APPROVED
Limited building only review
Permit holder responsible for full compliance with the code

PROPOSED
RESIDENCE
FOR
ANDREW & ANITA
RUHLAND

fFOUNDATION PLAN

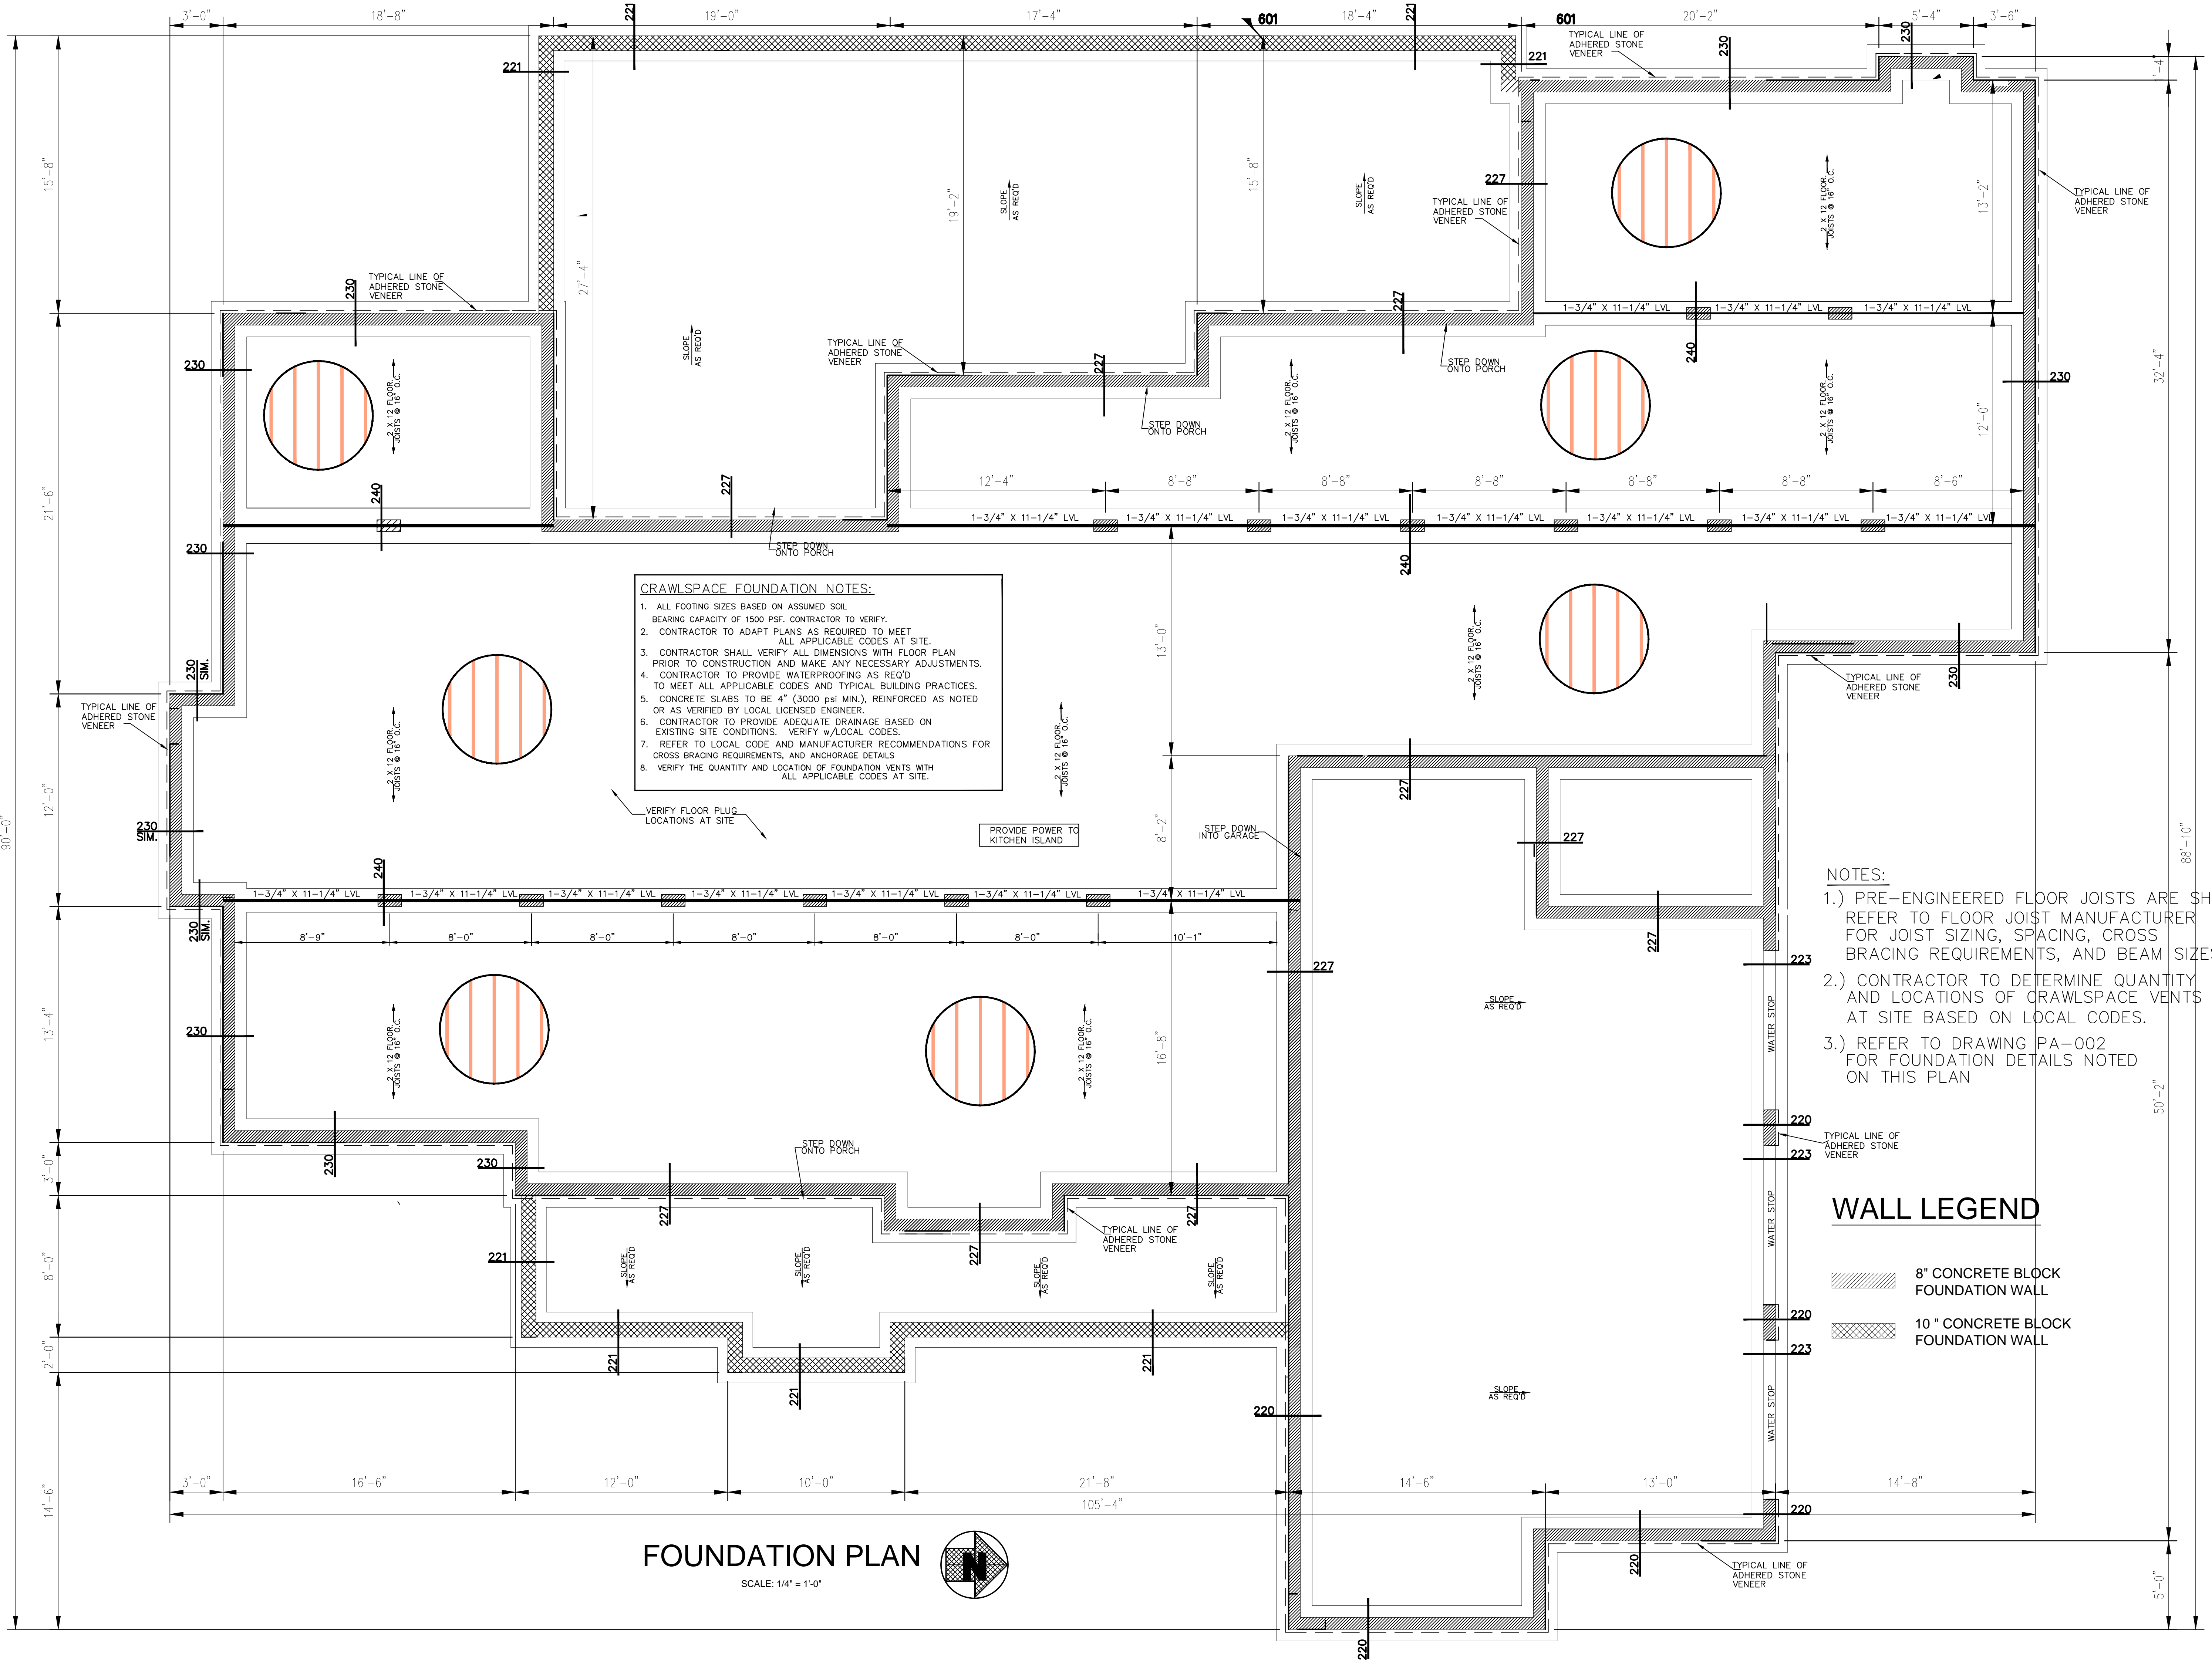
MUST USE I JOISTS. 2x12 WILL NOT SPAN THIS FAR

~~MUST USE I JOISTS. 2x12 WILL NOT SPAN THESE DISTANCES~~

USE UPDATED
LAYOUT LAST
PAGE
